## Appeal Decision

**Appeal Ref: APP/R5510/D/24/3350588**

**1 The Croft, Ruislip, Hillingdon, Middlesex, HA4 0SF**

- The appeal is made under section 78 of the Town and Country Planning Act 1990 (as amended) against a refusal to grant planning permission.
- The appeal is made by Mr Shamsul Islam against the decision of the Council of the London Borough of Hillingdon.
- The application Ref is 629/APP/2024/965.  
The development proposed is described as: 'Raising of piers 4-11 & infilling with black open grills along with sliding security gates.'

Proposed Boundary Wall Plan reinstated after the Collapse - Details Approved under
Application ref. 629/APP/2023/3636 - Scale 1:100@A3

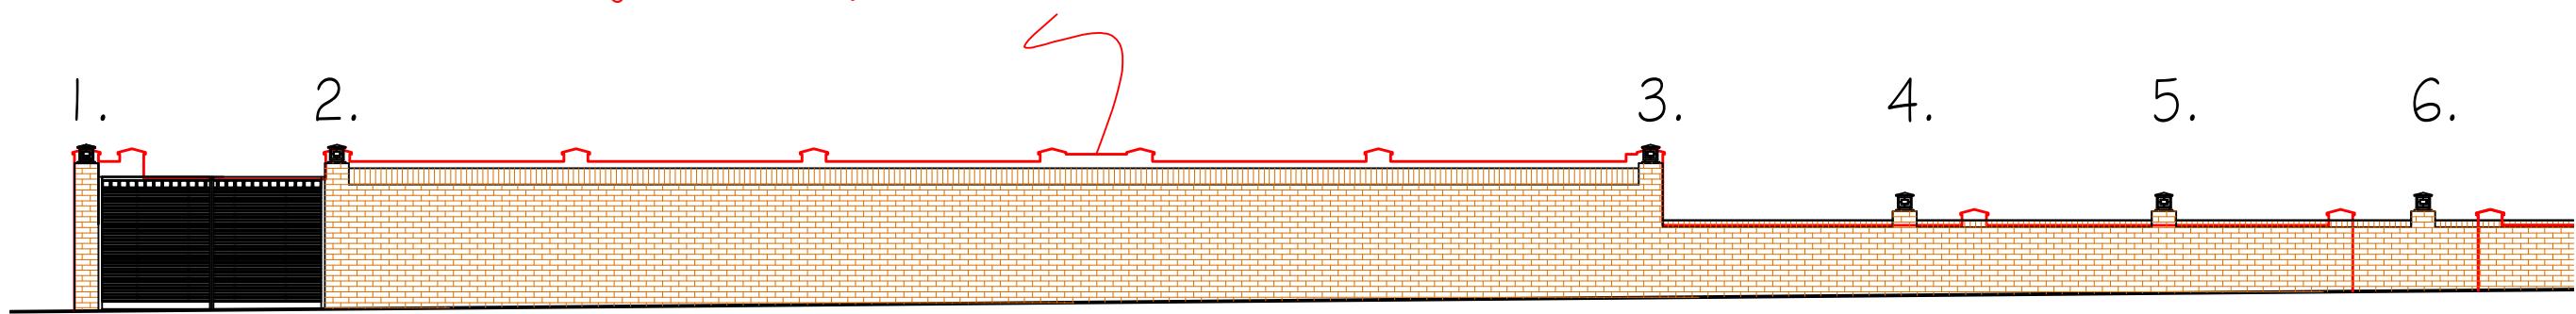
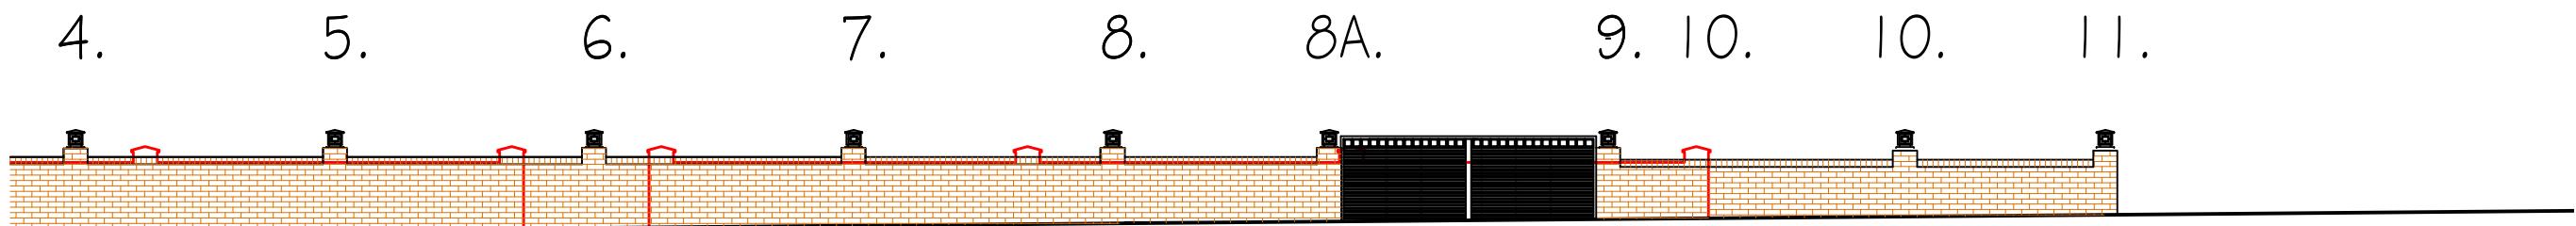
9. My attention has been drawn to a previous planning permission, Ref 629/APP/2023/3636, described by the appellant as a fall-back position. However, that permission is for a considerably shorter front boundary treatment and so it does not justify the appeal development before me.

Proposed Boundary Wall Plan reinstated after the Collapse - Raising of Piers 4 - 11 & infilling with open grills - Scale 1:200@A3

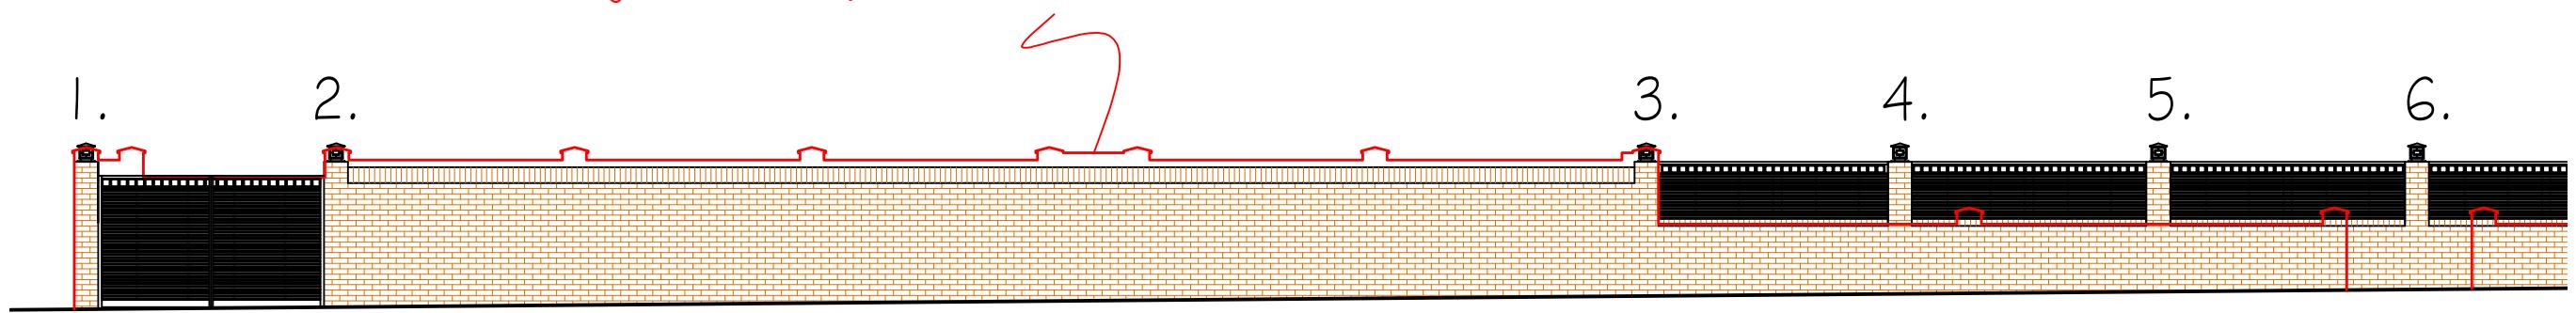
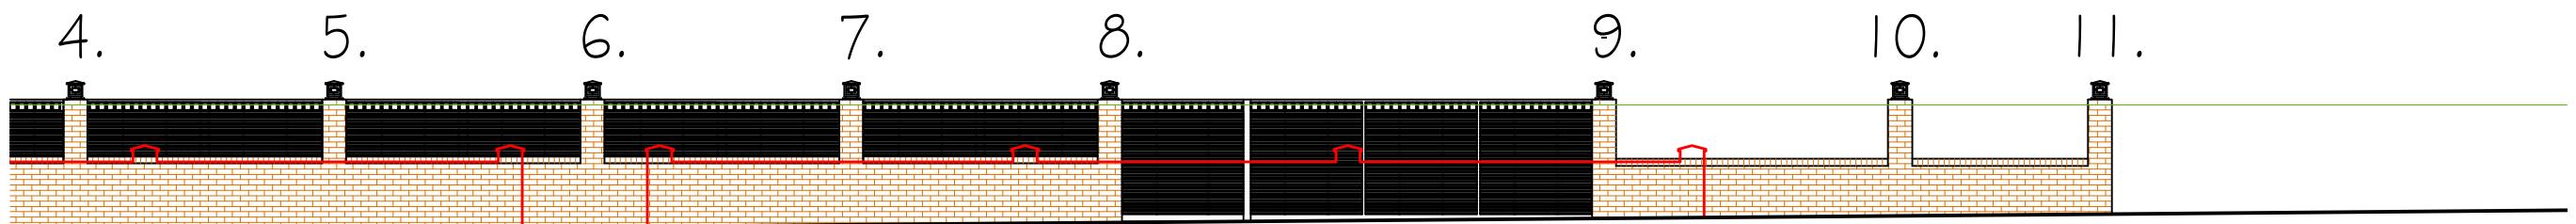
7. The proposal seeks to increase the height of the piers of the low brick boundary wall, infill the gaps between the piers with black grills and install sliding security gates. Whilst the piers would be constructed in brick, the height of the piers would be considerably higher than other front brick boundary walls in the area. The appellant describes the grills as 'open', such that they would allow views into and out of the appeal site. But this is not what is shown by the drawings provided to describe the appeal development. These drawings show the sections between the piers would be solid, as would the proposed gates. Overall, the proposed arrangement would be uncharacteristic and incongruous.
